**Subject:** FW: BE/176/21/PL - The Cottage, Shripney Road, Bognor Regis - WSCC Highway Comments/Query relating to the submitted planning documents

**Subject:** BE/176/21/PL - The Cottage, Shripney Road, Bognor Regis - WSCC Highway Comments/Query relating to the submitted planning documents

I've just been reviewing the above application and would raise the following points/query's.

Drawing:
2109058-02A

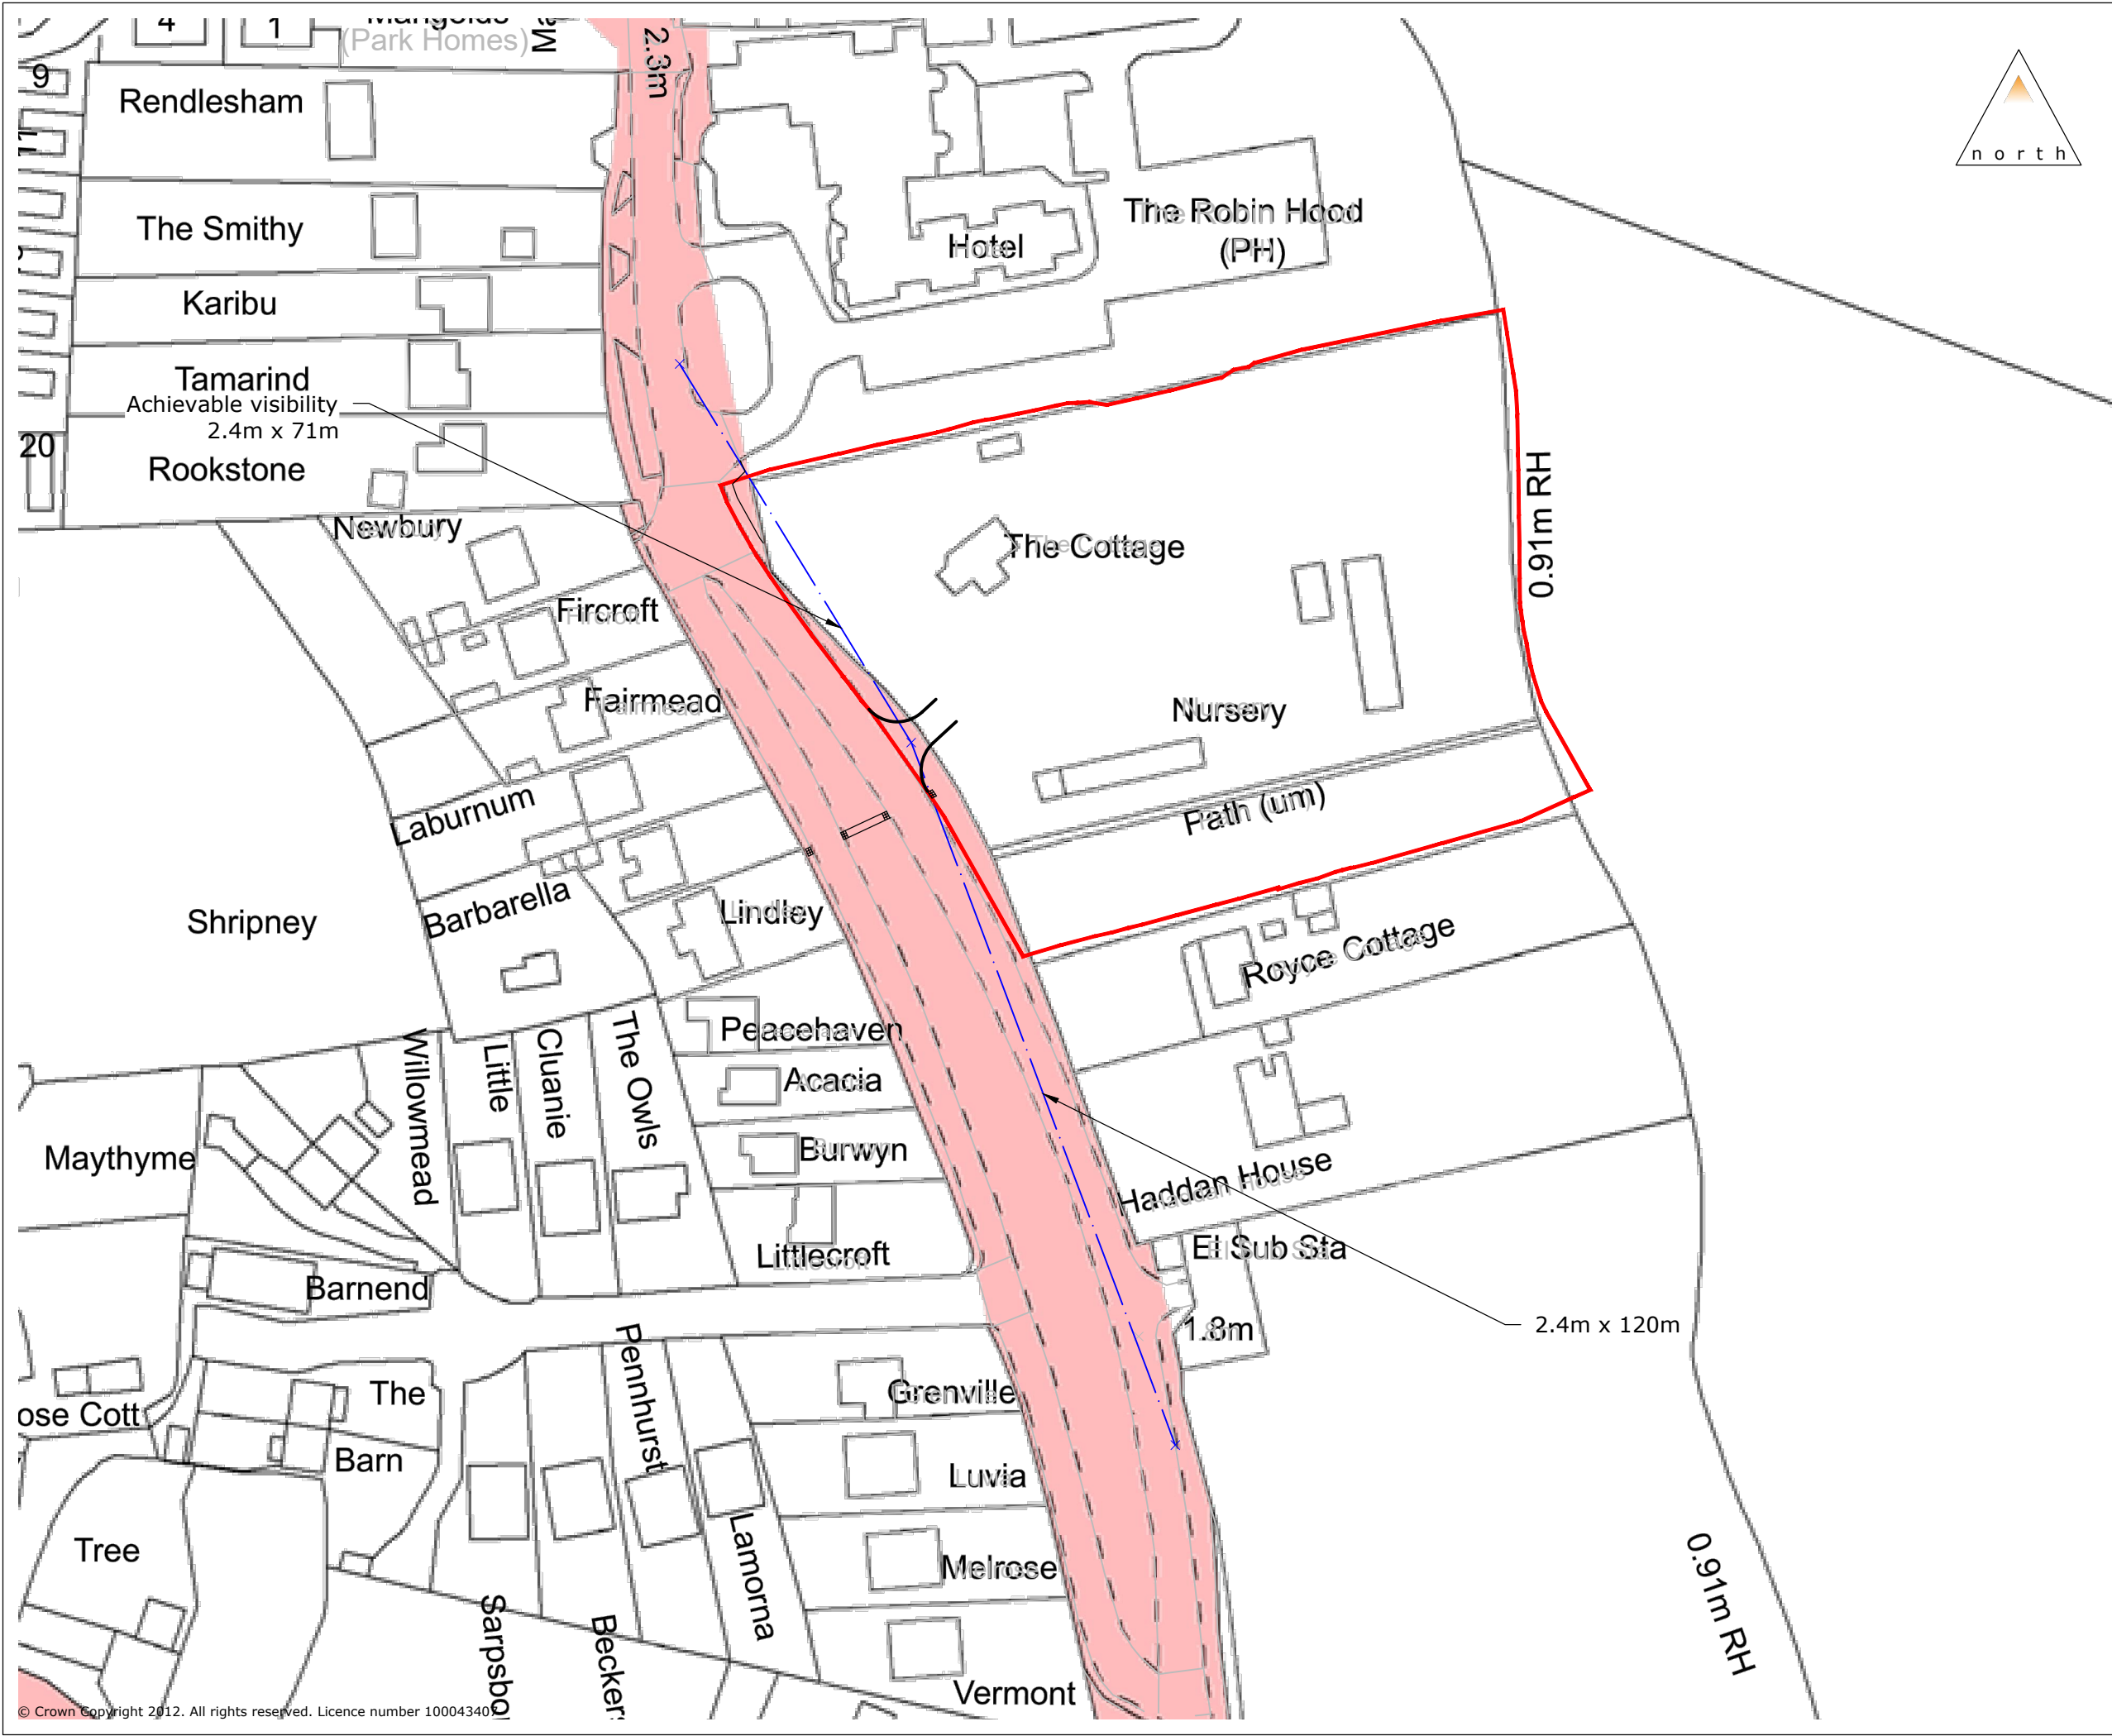
- Revised Drawing no:PO22-9PA-03A (Proposed Site Plan) as submitted on 16<sup>th</sup> December 2021 on the planning portal details a 'New vehicular and pedestrian access'.
- The 'Access Overlay' drawing submitted 16<sup>th</sup> December 2021 (Drawing no: 2109058-04) indicates the access being shifted north. Also the previously proposed/approved uncontrolled pedestrian crossing point shifting north too, both closer to the bend in the road.
- The Access visibility plan (Drawing no: 2109058-02A) demonstrates 71m visibility to the north (towards the Robin Hood Pub) & 120m to the south as previously approved under BE/63/17/OUT.

Can the applicant/Motion confirm if the access is being shifted or not? As this will affect how we progress this application and what documents we would require being submitted.

If the access is shifting, then we would require a new Stage 1 RSA report to be undertaken, to include also an Audit Response Report in line with GG 119. If the access is shifting closer to the bend in the road as well as the pedestrian crossing, we would like clarification on if the approved visibility shown (71m north and 120m south) is still achievable or what visibility is achievable, wholly within adopted highway land or land under the control of the applicant. Also visibility north and south on both sides of the road from the pedestrian crossing to be demonstrated and run past the Audit Team.
